Green Hill Solar Farm

Statement of Common Ground: National Highways

Document Reference: EX2/GH8.3.7

Sheet 13 of 18

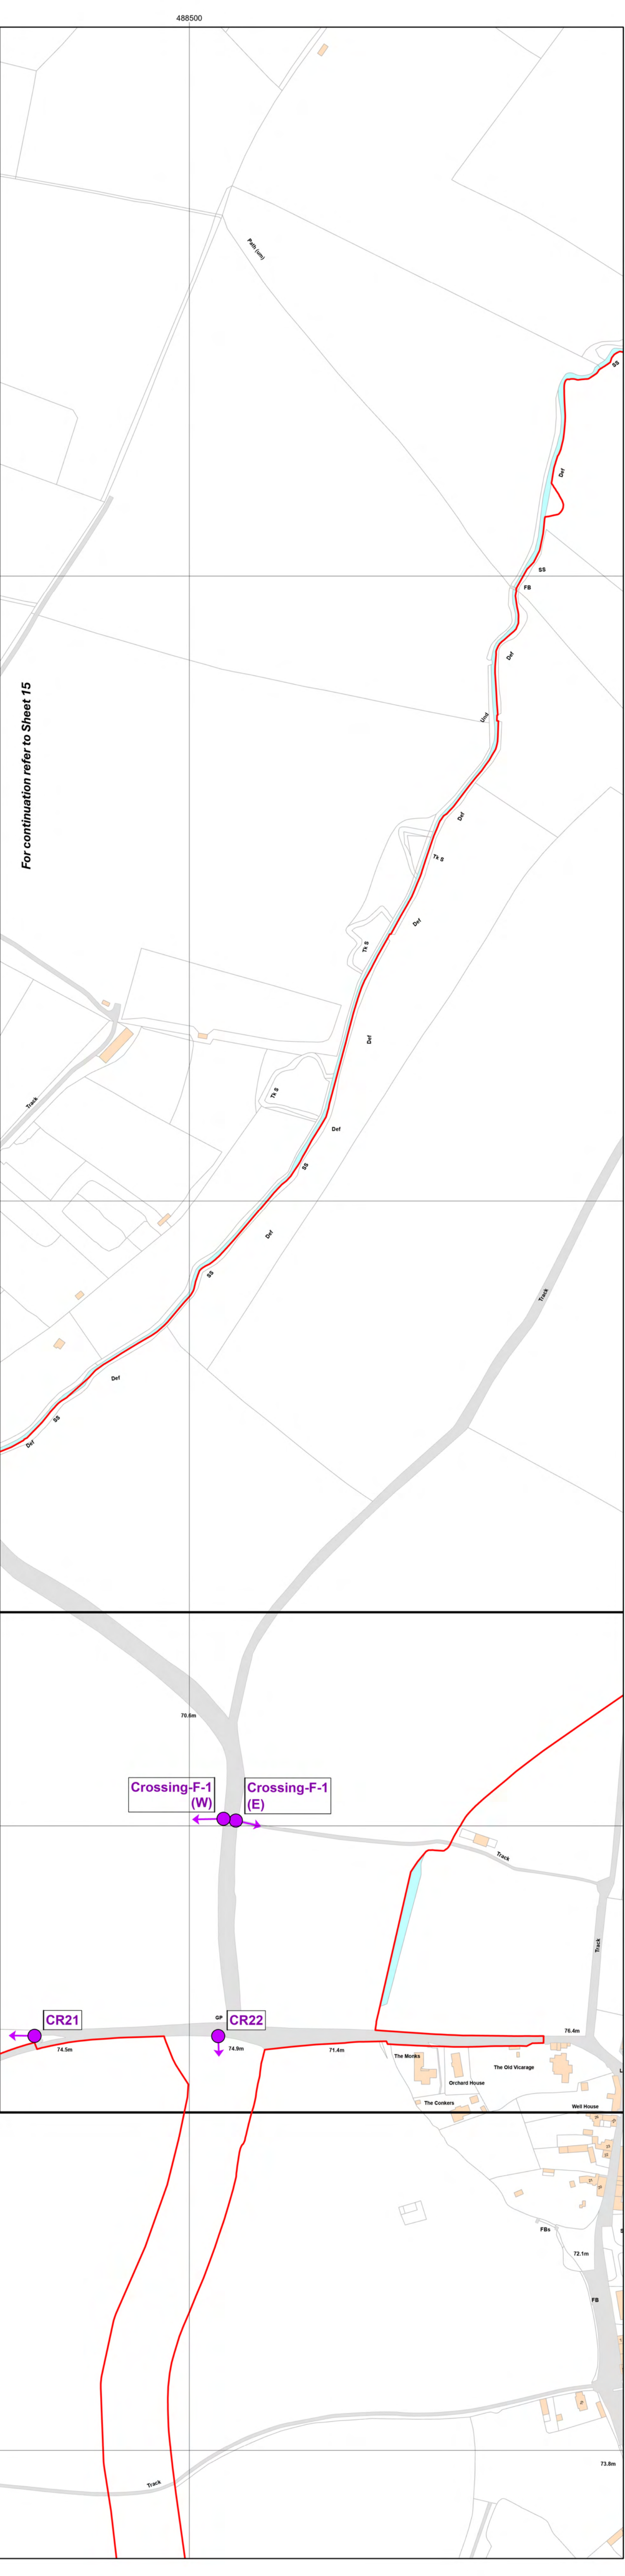
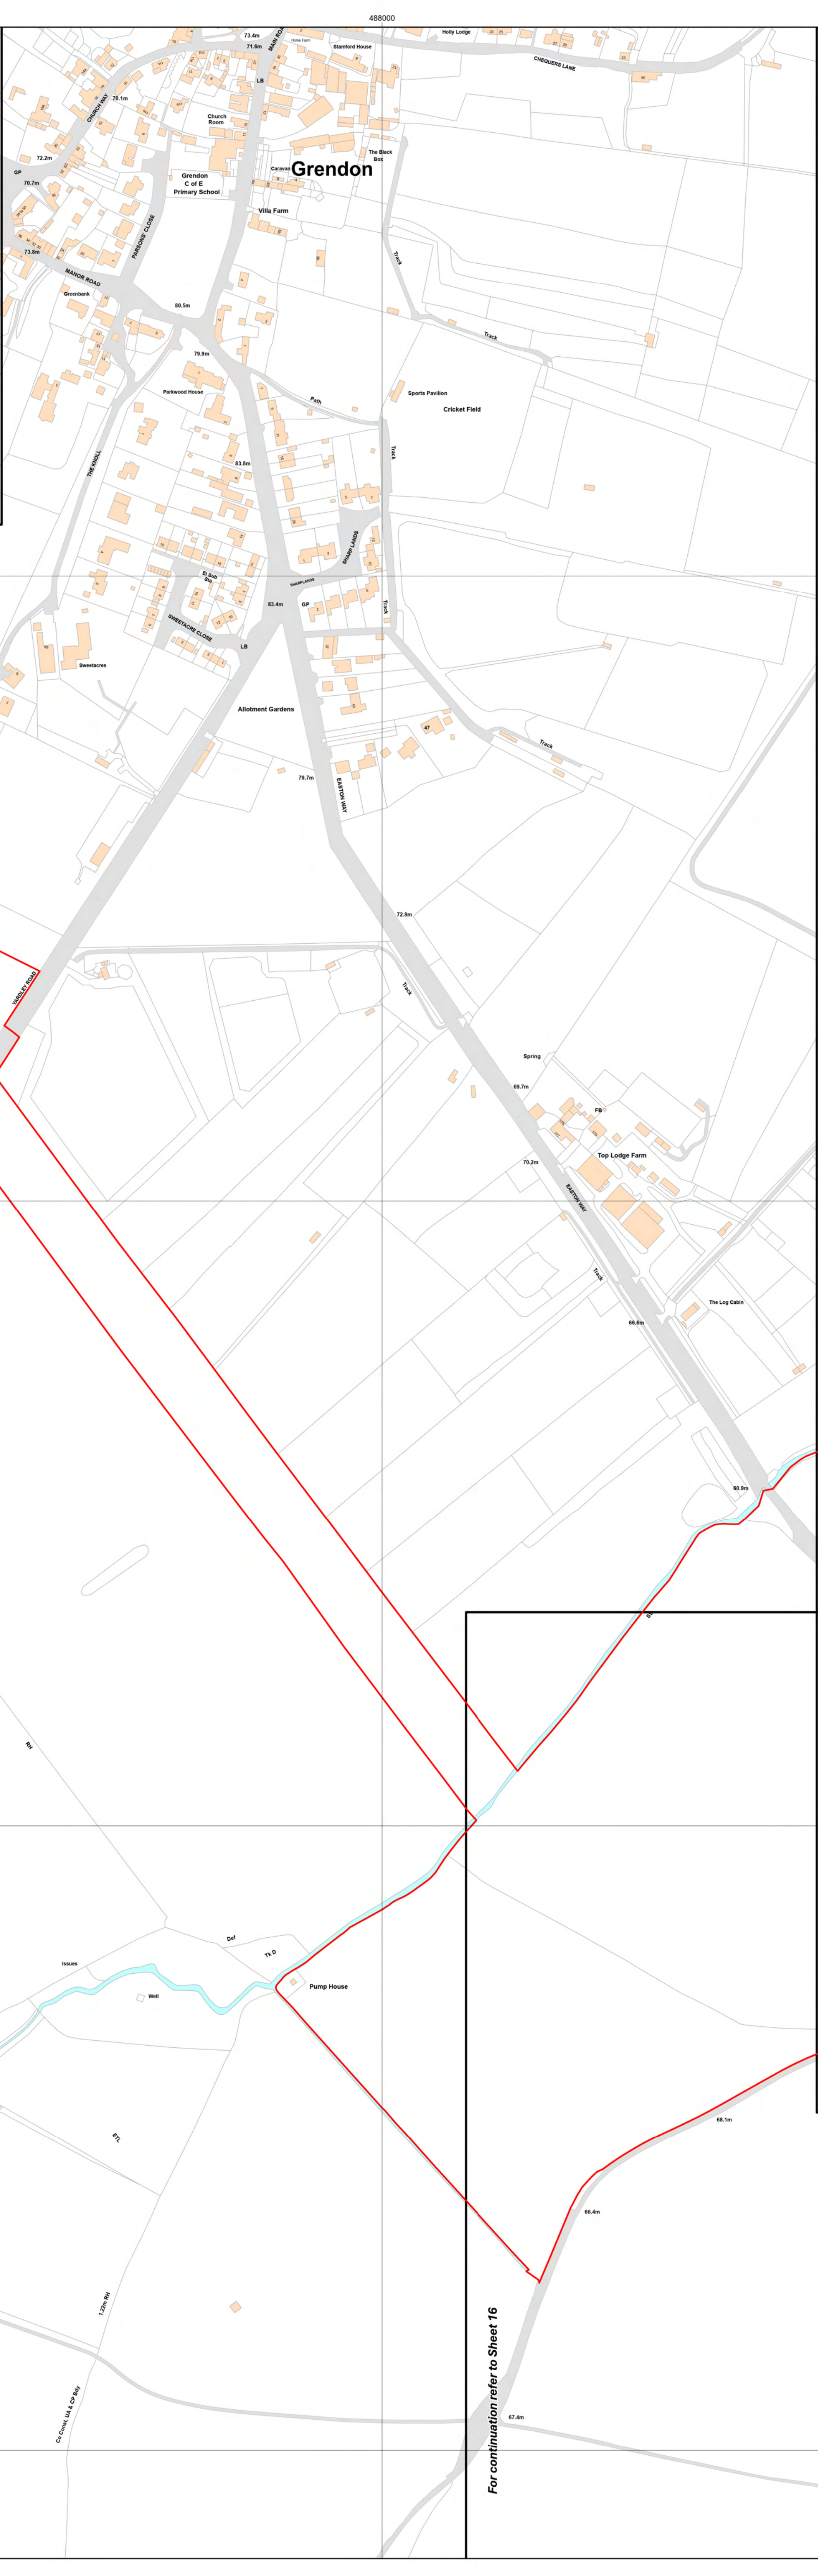
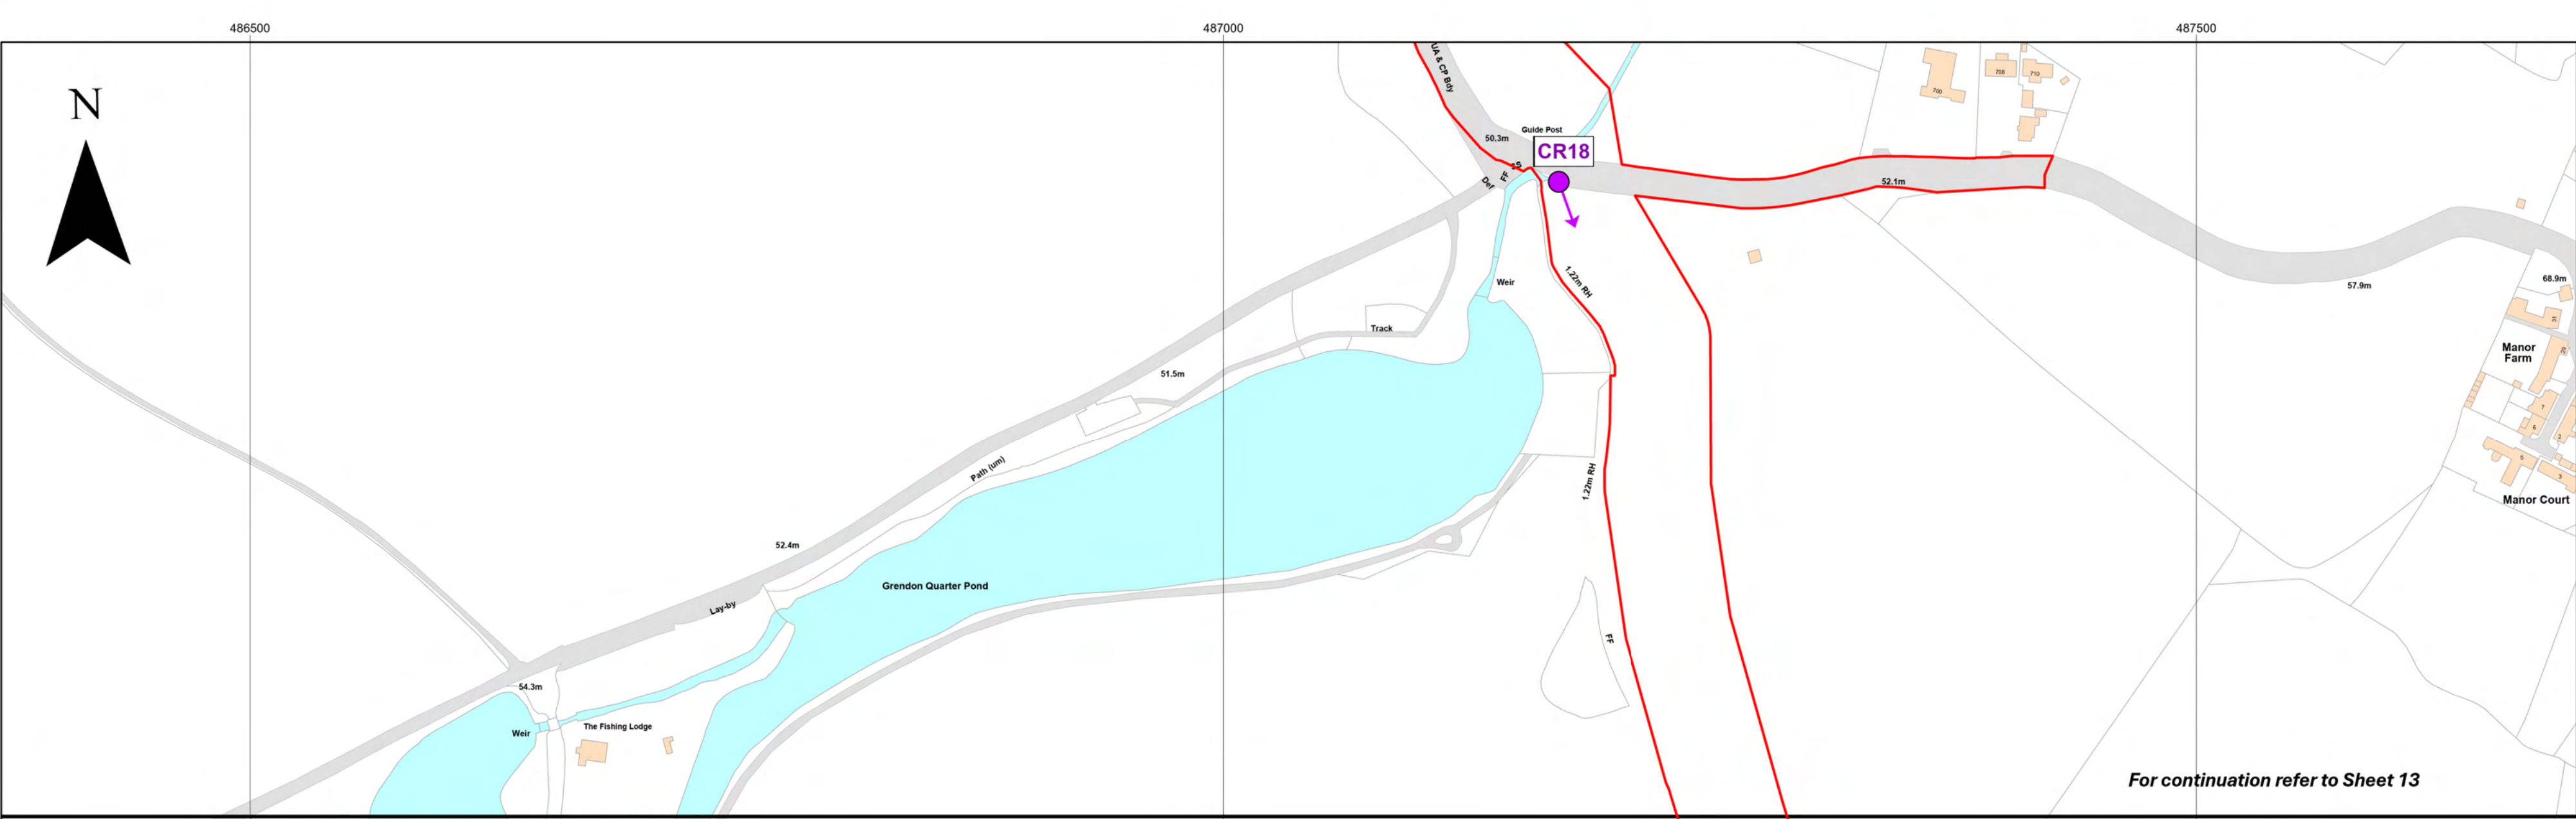
Matter	Details of Matters for Discussion	Applicant Position	Consultee Position	Status
				<p>disturbance to our property, including a demonstration of the options considered to avoid such disturbance. Cost alone is not an acceptable justification.</p> <p>Details need to be agreed including agreeing the protective provisions with National Highways in order for NH to remove its objection to the scheme.</p> <p><u>Change 7 – Change to Application</u></p> <p>An additional area of approximately 0.12 ha is proposed to be added to the Order Limits. Only the compulsory acquisition of rights (not the land itself) is sought for this area.</p> <p>All matters outlined above will continue to apply to the revised Order Limits included within Change 7.</p>	
TA-003	Work No. 8A	Works to facilitate those access works at works no 8a will impact the SRN at specific locations due to a	Physical works are not proposed in this area. As stated by National Highways, traffic management may be	Access CR15 marked on the Access to Works Plan (APP-012), located south of the A45 on Grendon Road,	Matter under discussion

Matter	Details of Matters for Discussion	Applicant Position	Consultee Position	Status
		need to introduce temporary traffic management on the SRN	required for periods during the construction. The precise nature of those measures, together with their timing and duration is not known at this time but will be confirmed in the detailed Construction Traffic Management Plan which is set out in the OCEMP Revision A [REP1-145] , as secured in Schedule 2, Requirement 15 of the Draft DCO Revision A [REP1-008] . In addition, the Applicant is engaging with NH to agree a form of Protective Provisions, to manage the interaction of the Scheme with the SRN.	<p>and access points CR12 and CR13, also referenced on the Access to Works Plan (APP-012), located off the A45 eastbound slip road at B573 Earls Barton Road, may need to introduce traffic management.</p> <p>National Highways requires additional information from the applicant to confirm the scope and impact of the proposed works in this area.</p> <p>National Highways acknowledges that the detailed CTMP will address the temporary construction traffic management impacts. National Highways also requests to be consulted on this under the Schedule 2 requirements.</p> <p>However, National Highways still requires confirmation that no physical works are proposed in this area. As stated below, Schedule 4 (Article 8) <i>Streets Subject to</i></p>
